Ad Astra Aviation Limited Planning response (AALSUB0408-26) to an application for planning permission

Reference: EN0110012

Proposal: Solar farm with associated battery energy storage system (BESS) located near Selby in North Yorkshire

Drawing Title  
**Figure 2.1**  
**Illustrative Site Layout**  
**Sheet Number 2 of 7**

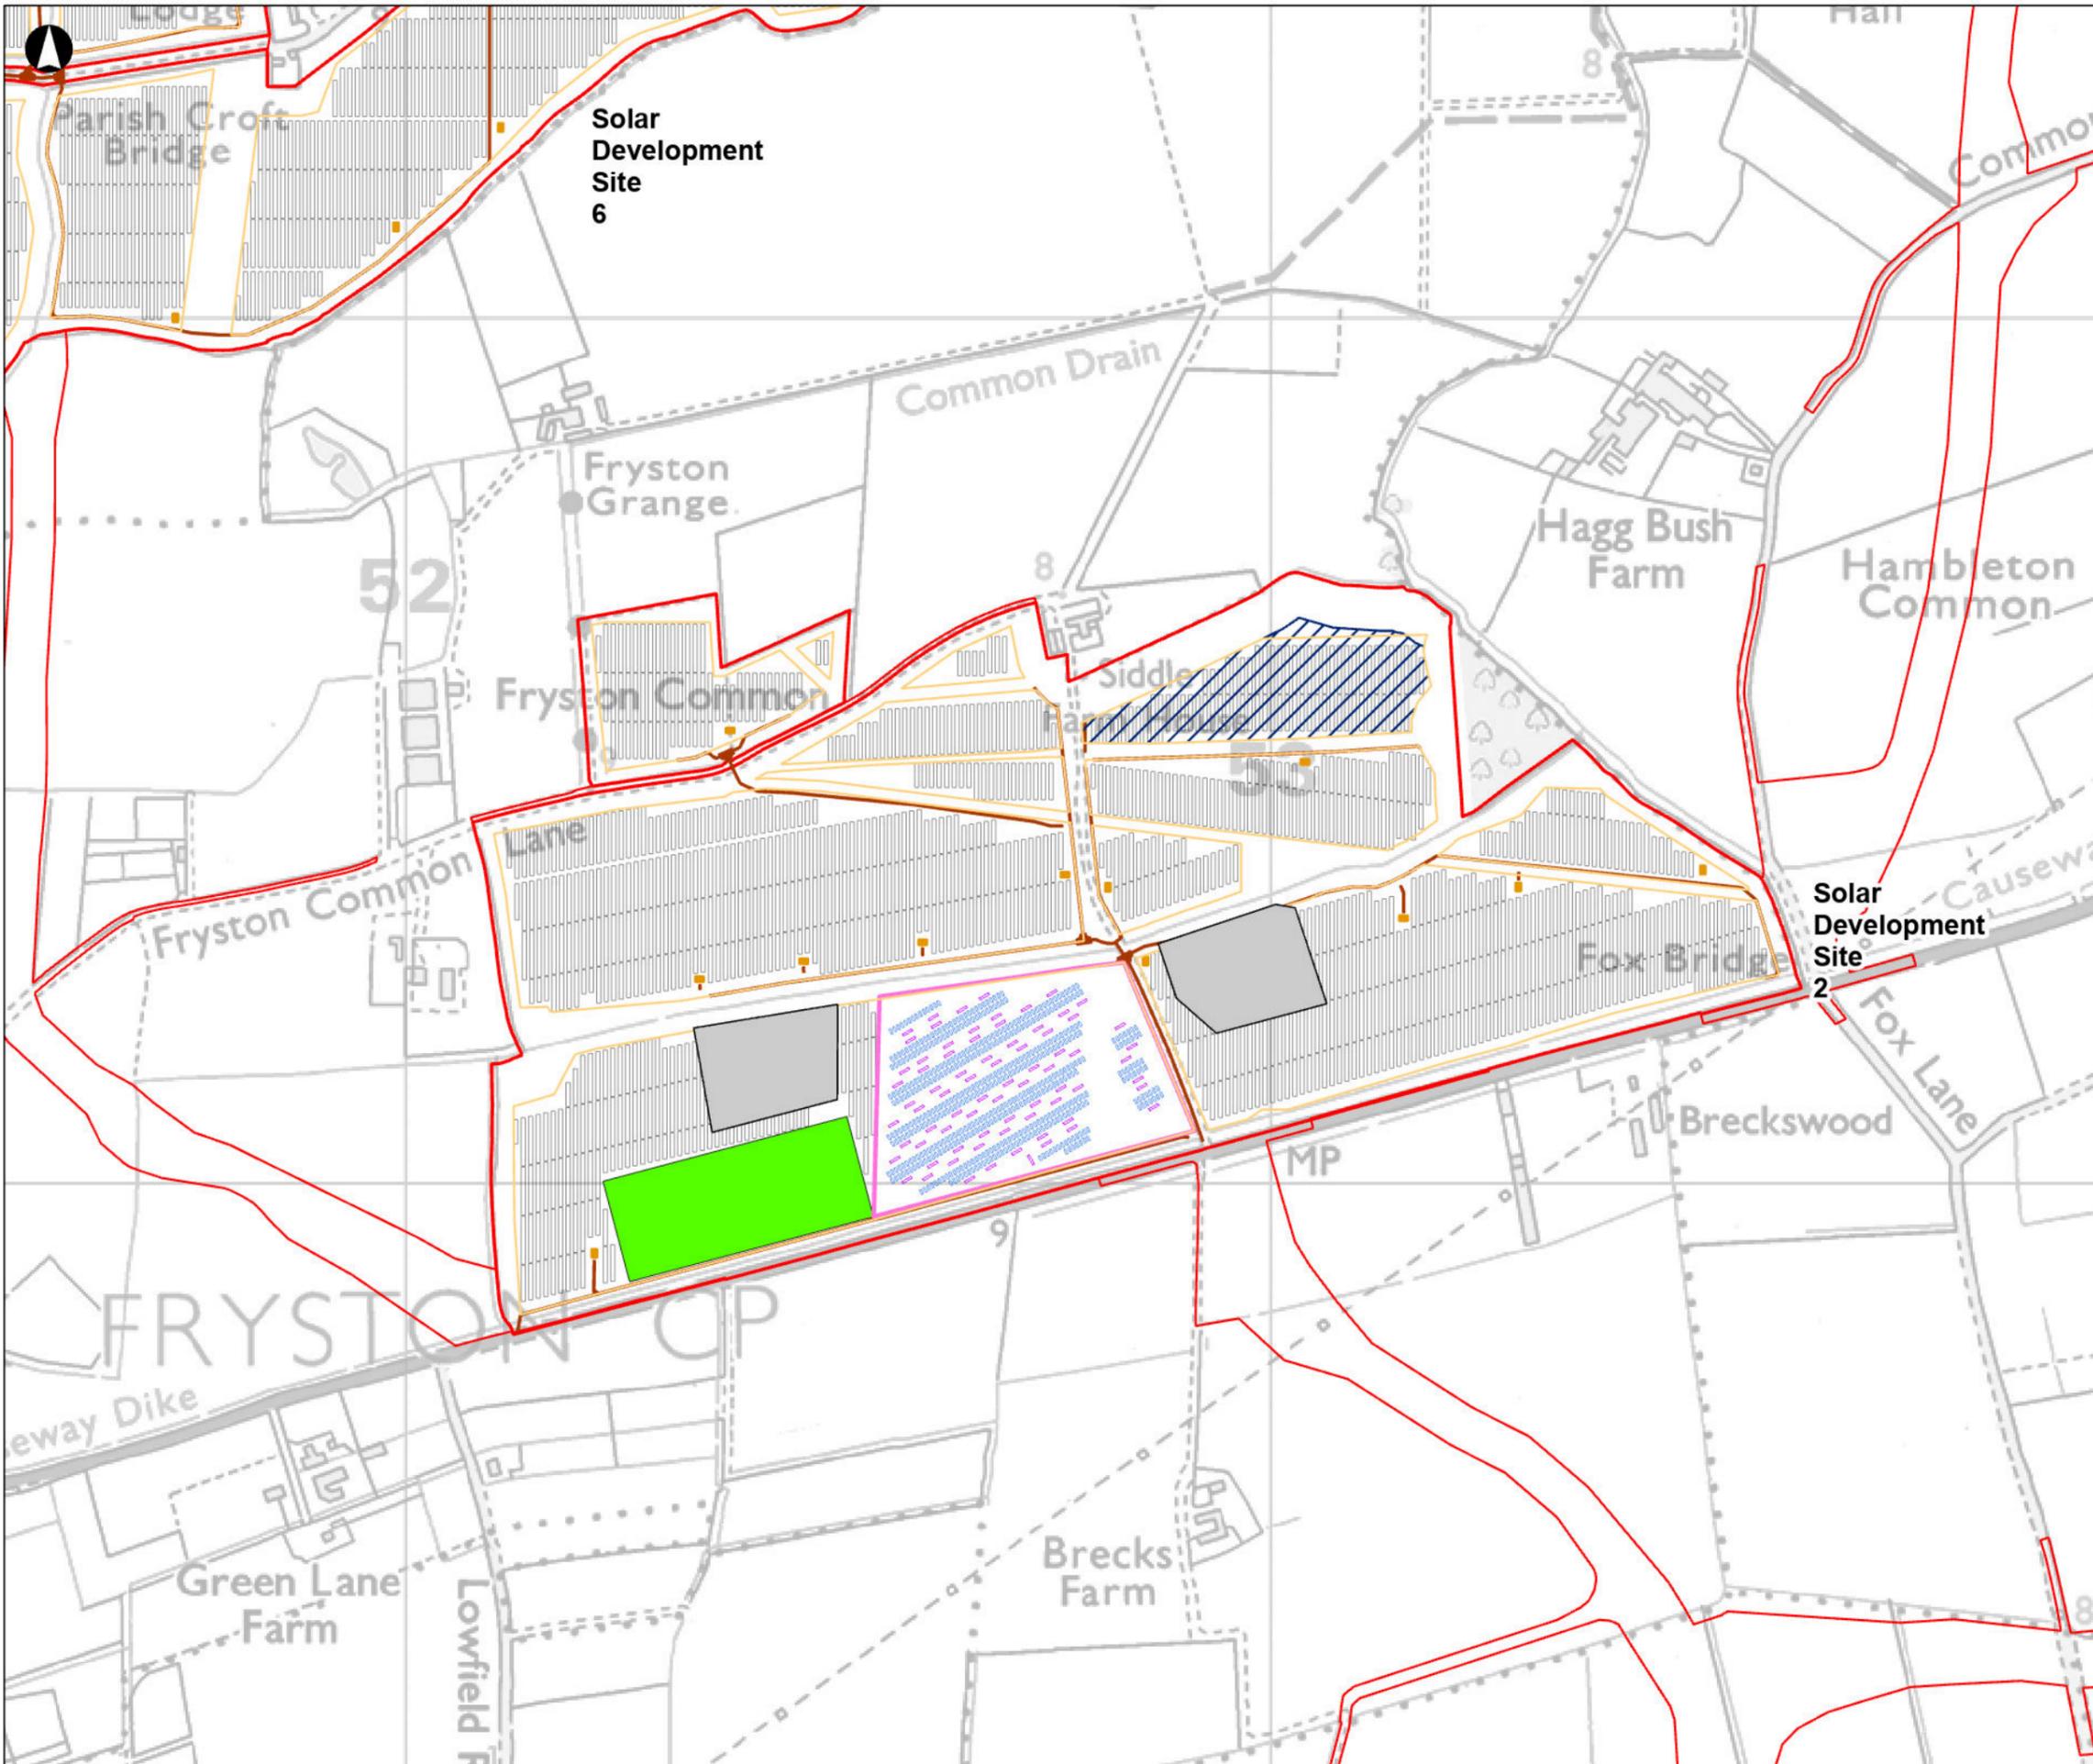
The reality is that whilst the suggestion of such a gap has clearly been made with good intention, it offers extremely limited value and is highly problematic for a variety of reasons. The proposed gap sits in a narrow field within development site 6. The length of the proposed strip is less than 350 meters which is noticeably short indeed. Furthermore, its width is understandably limited.

Crucially, such a strip could only ever conceivably represent an option to aircraft on the least used runway 01/19 which is only used when particularly strong northerly or southerly winds are present.

Importantly, terrain immediately south of the aerodrome boundary rises considerably with two distinct earth mounds at the old mine site. Terrain then drops again within development site 6.

This means that an aircraft would require to climb clear of the earth mounds and then aggressively descend to the short landing site provided by the EFATO gap whilst experiencing an engine failure. See figure 13 elevation chart.

The aerodrome is on the left-hand side of the red elevation chart shown in figure 13. The first mound climbs from 7m elevation to 18m. The second mound further right on the chart (south) climbs to nearly 30m before dropping back to nearly 8m elevation. In summary, this does not represent a workable solution for an aircraft in such an emergency. In fact, it would be very challenging for an experienced pilot to execute with a fully operational aircraft.

The downwind track associated with runway 10/28 overflies development sites 2 and 6, although on this track, aircraft will be at 1000ft with greater options.
